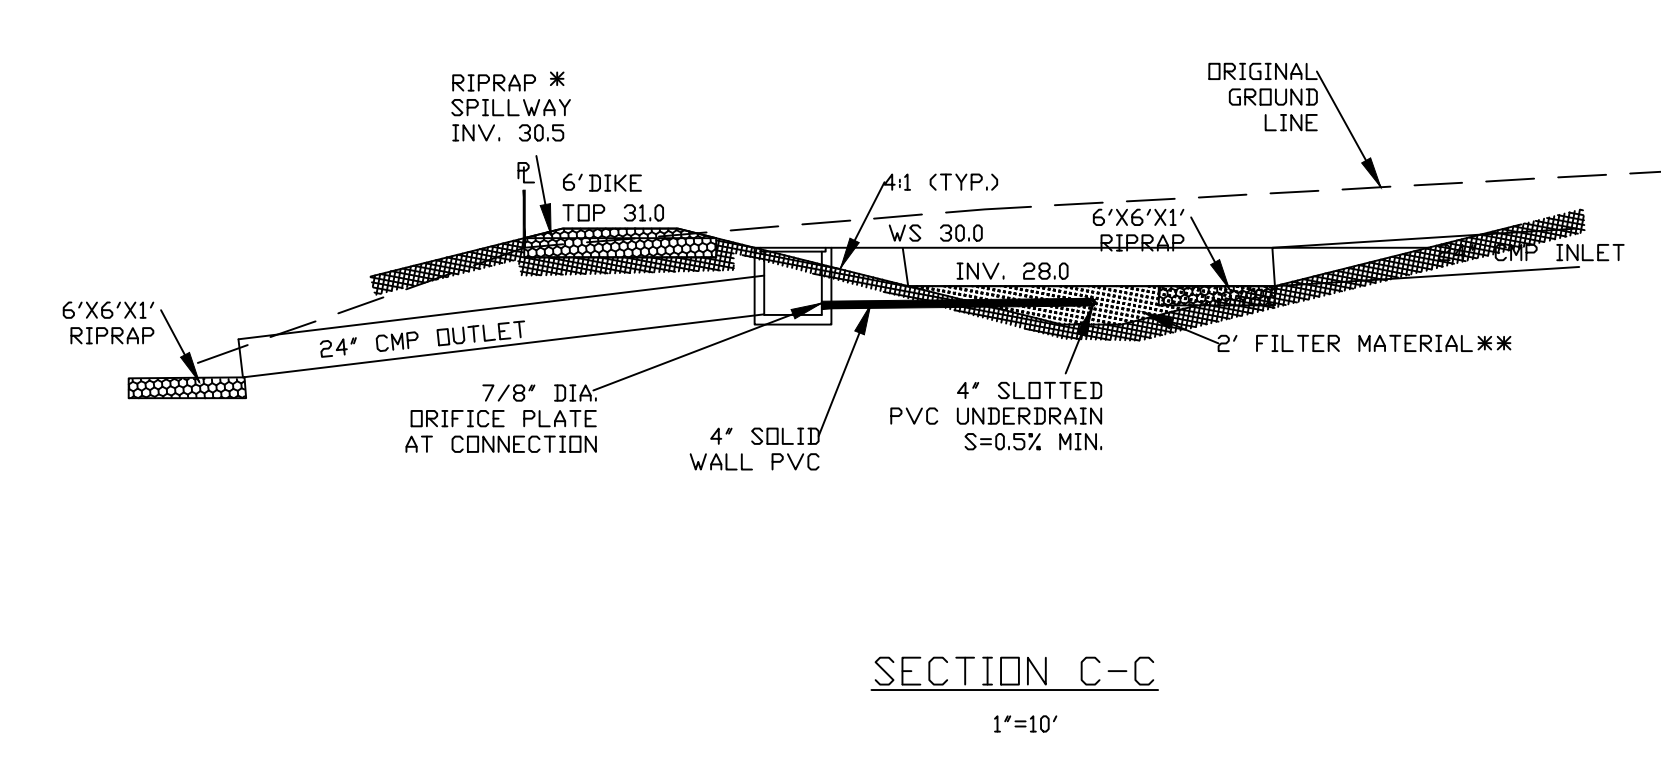
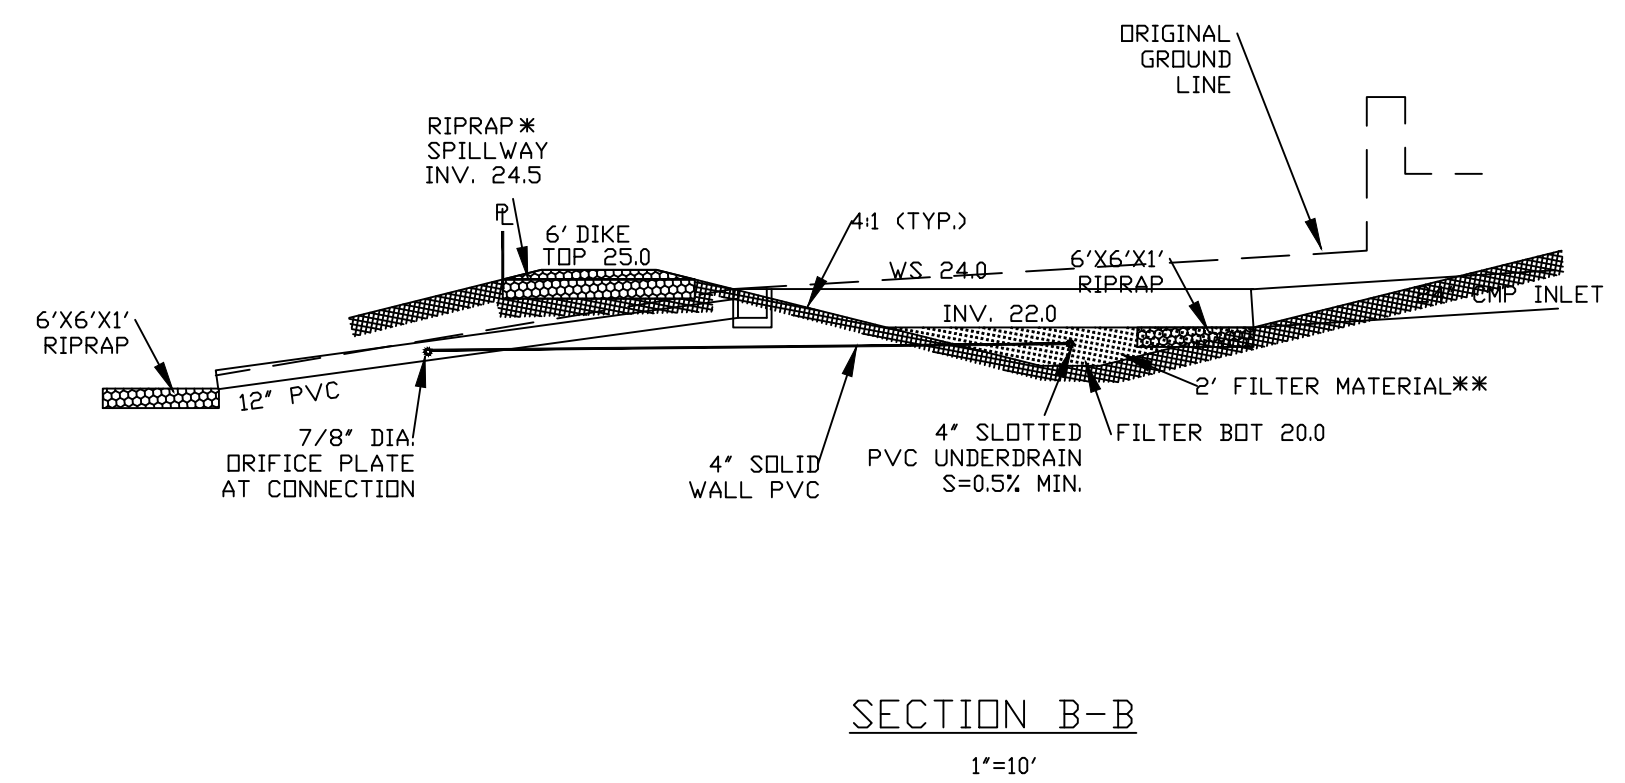
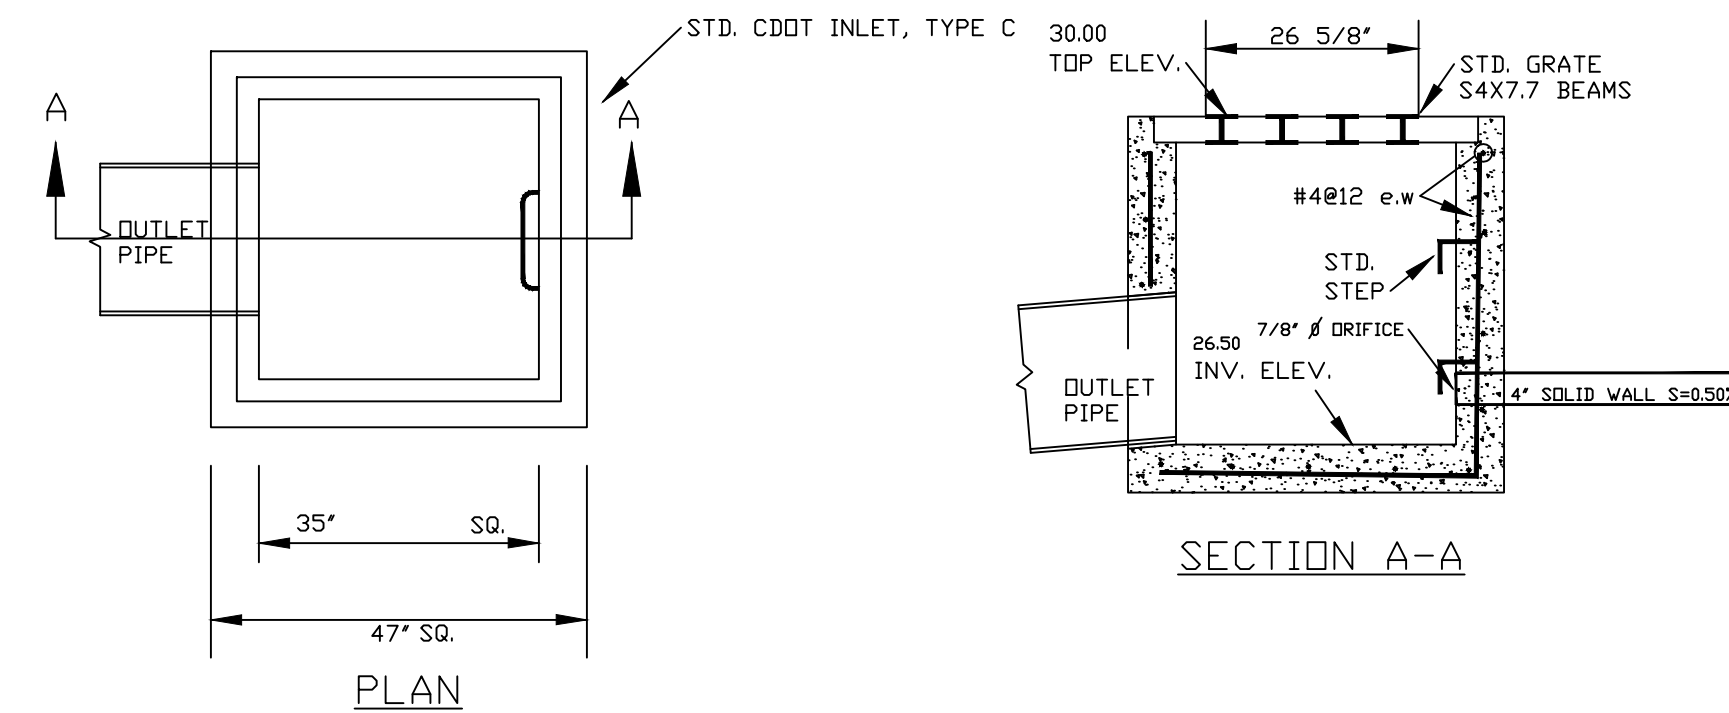
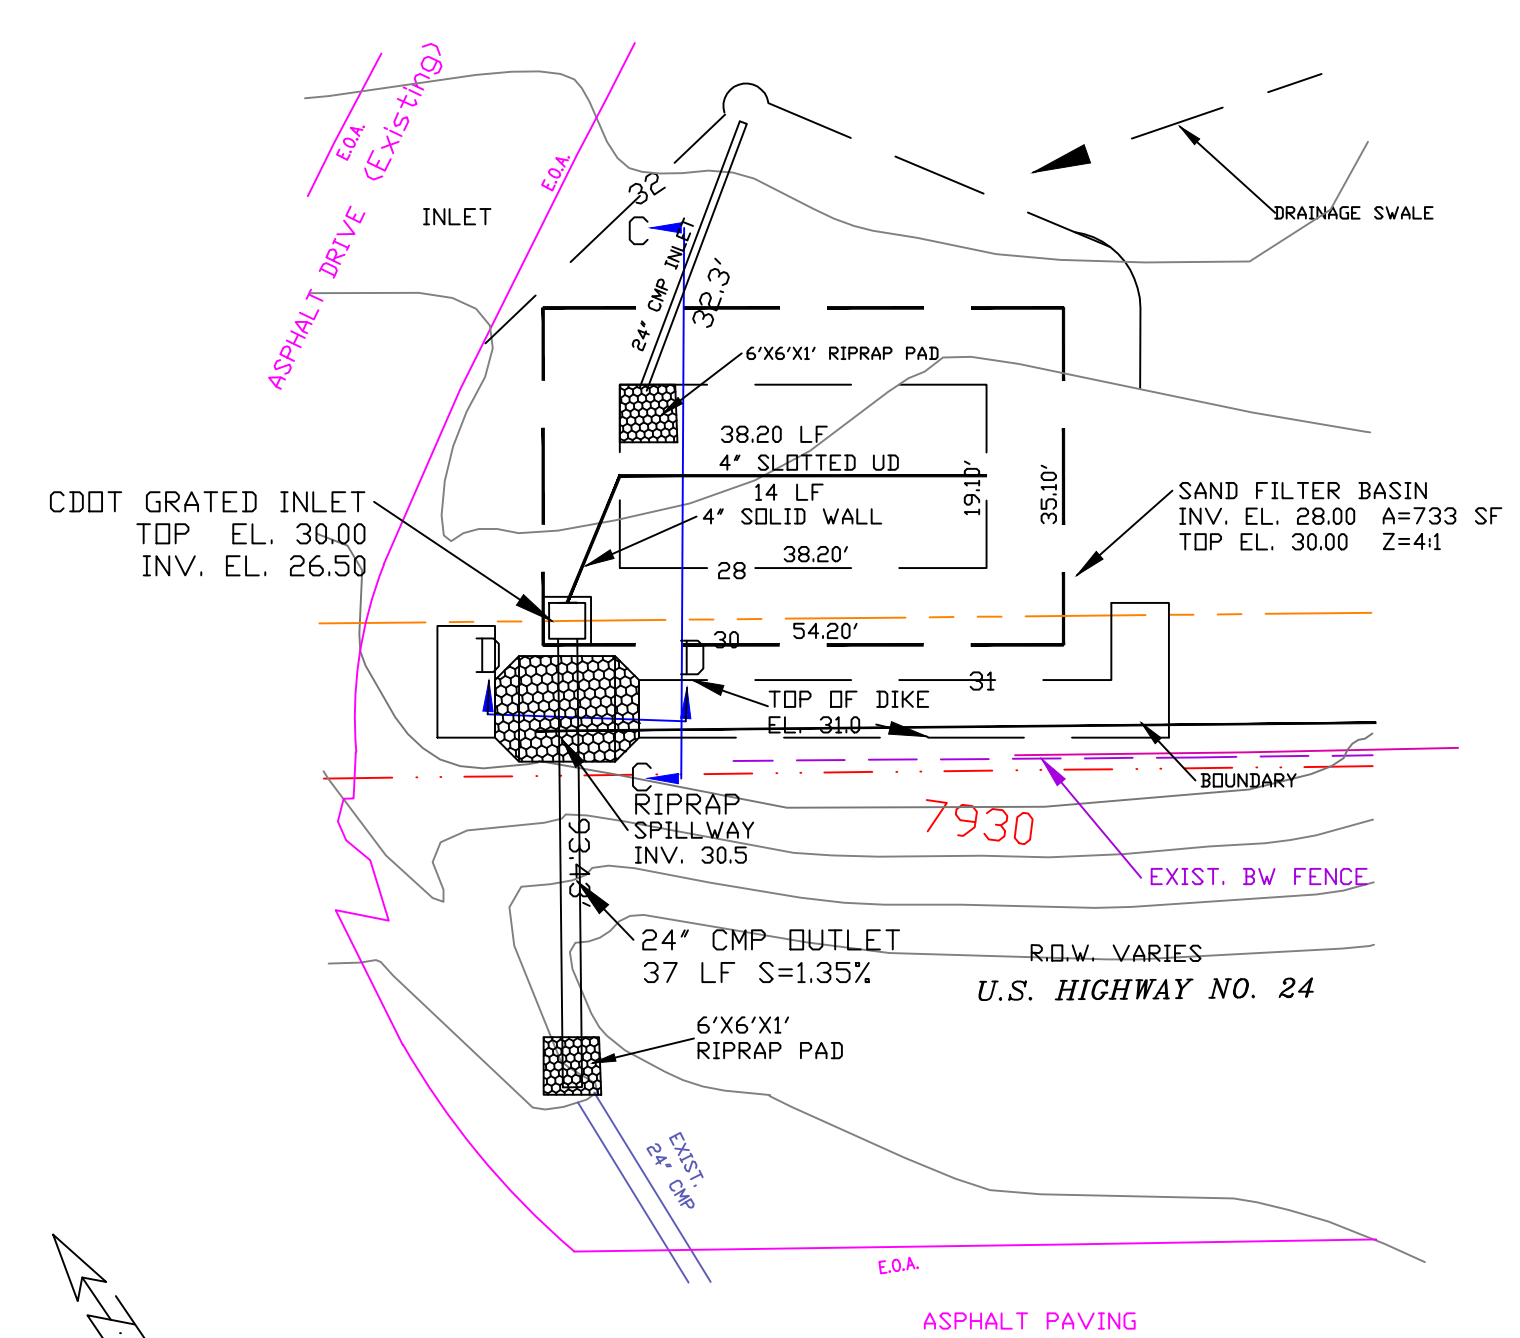
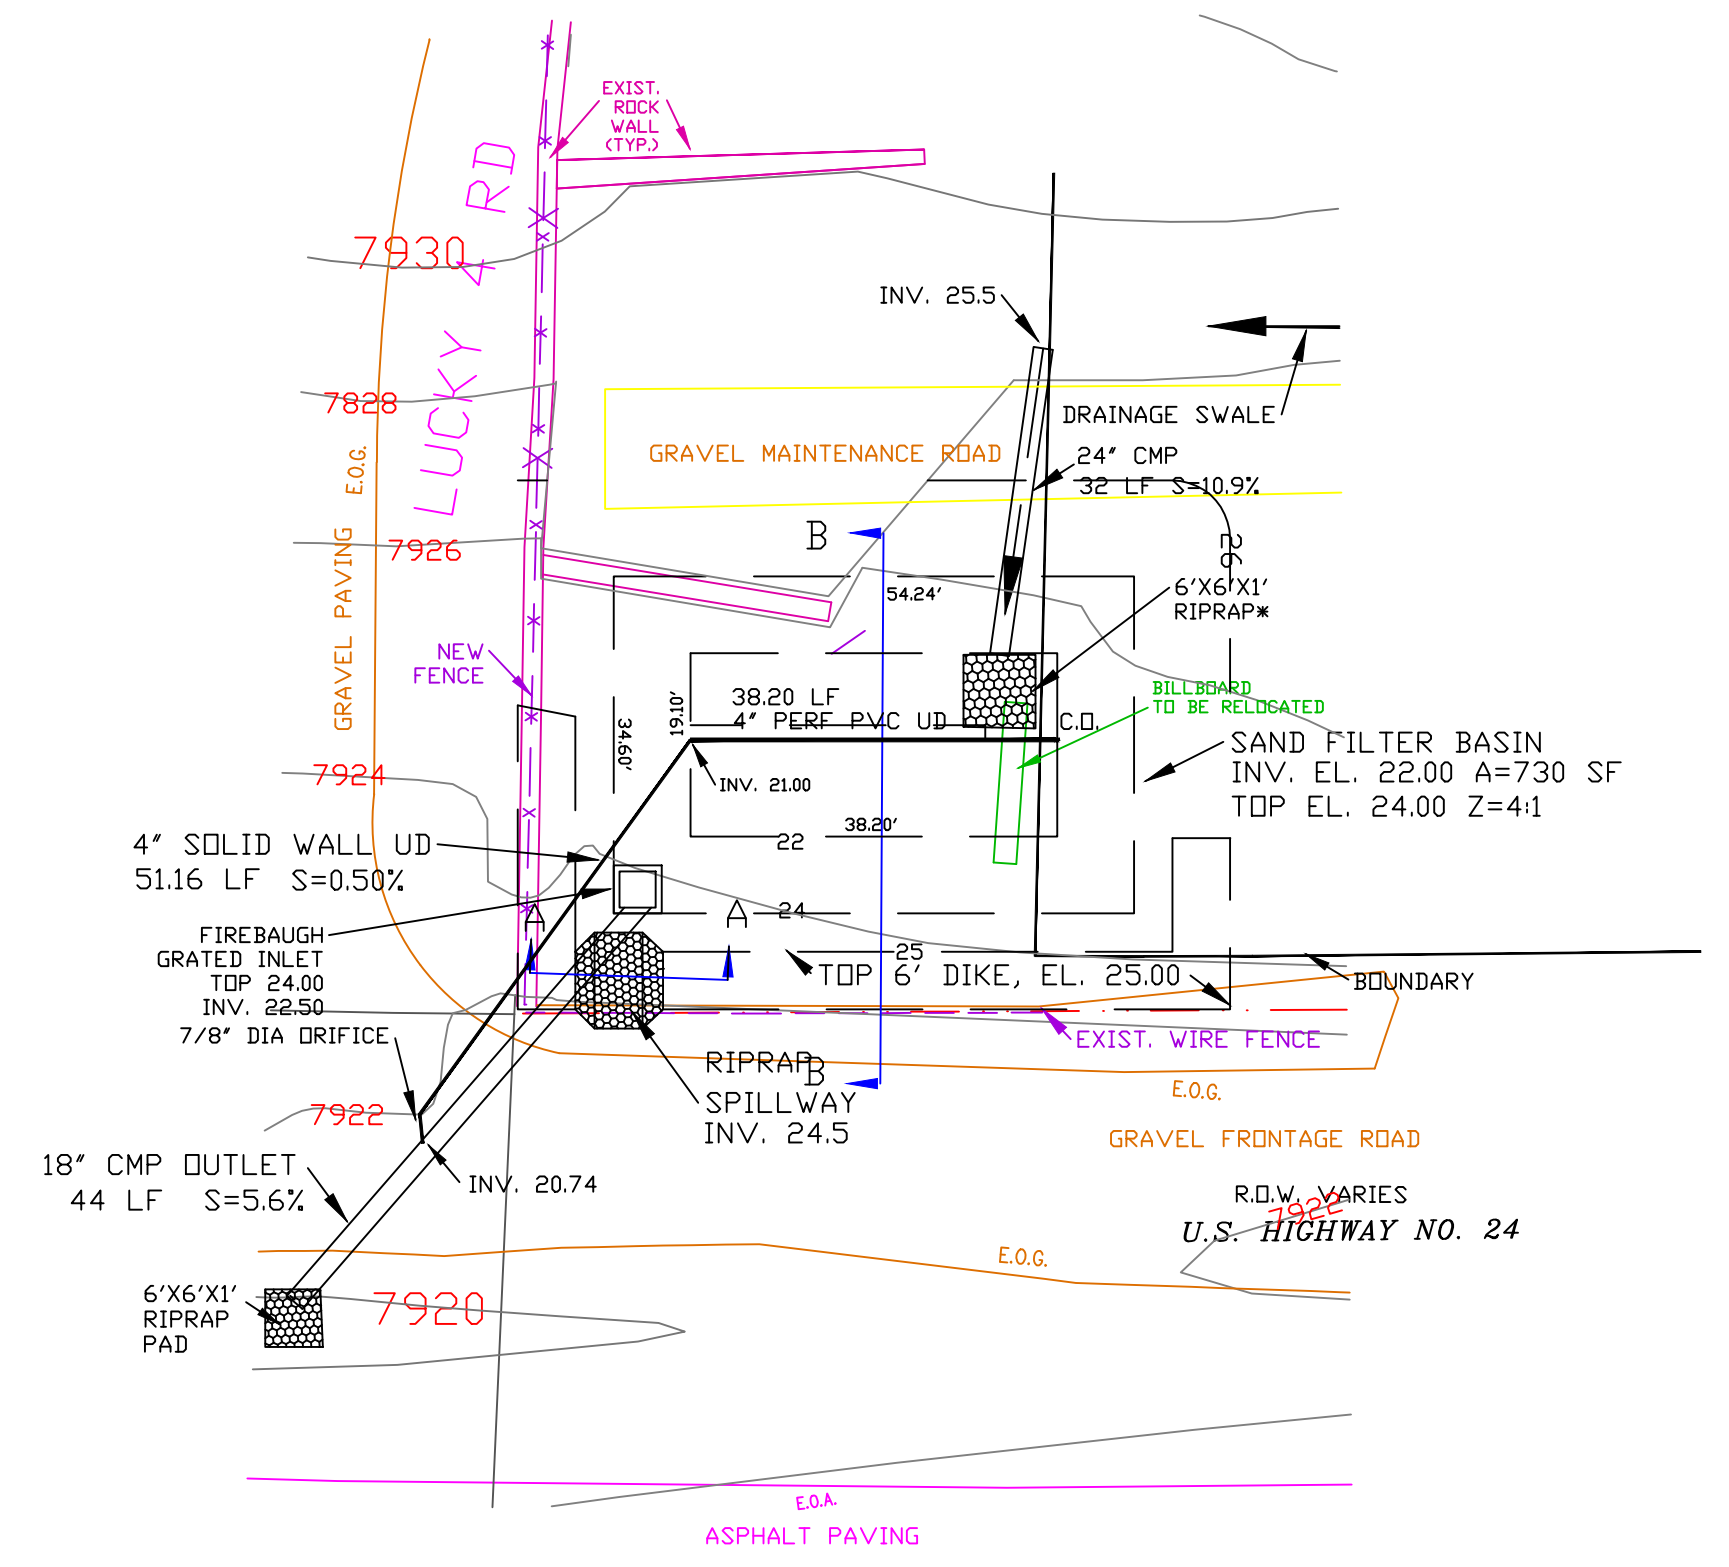
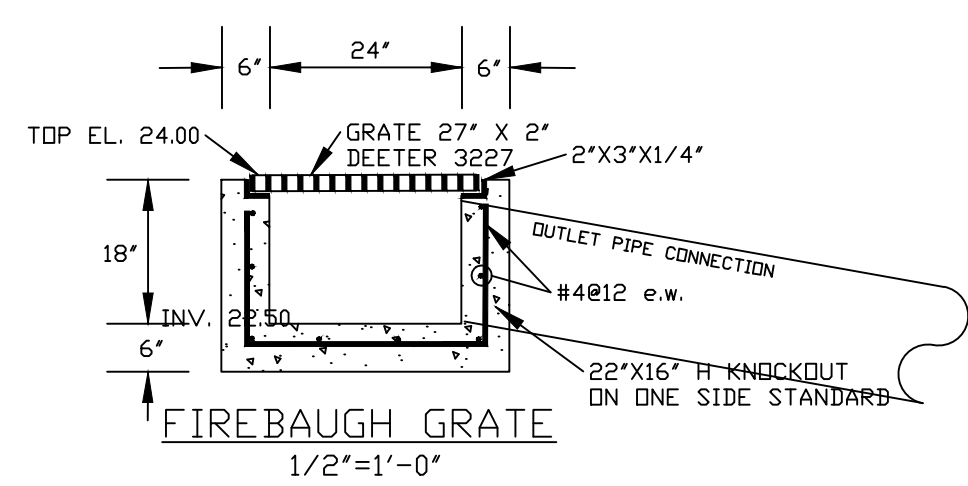
I'm assuming that the depth is supposed to be 1ft and not 1in. Please revise.

clarify where the connection of this 4" pipe occurs. How many LF of 4" pipe at what slope?

Per DCMv2 Section 4.3, outlet pipe should be 18" minimum. (UD Figure 6-a)

This type of soil riprap with topsoil is fine for the spillway but is not appropriate for the erosion protection at the bottom of the SFB where the inlet pipe outfalls. We don't want to encourage the growth of vegetation with the topsoil nor do we want to introduce more sediment into the SFB which will cause extra maintenance. So create a separate asterisk or text callout for these locations.

provide detail to show how orifice plate will be attached, what material it is made out of, etc.

Need to show vertical cleanout with 45deg elbows per MHFD Detail T-6 (page SF-8).

provide detail to show how orifice plate will be attached, what material it is made out of, etc.

Clarify why where the transition from solid wall to slotted occurs. Also show a section view of how underdrain is to be installed, as seen on pg SF-8 of MHFD Detail T-8

Please review MHD Detail T-6. SFB bottoms are to remain unvegetated. Side slopes should be vegetated.
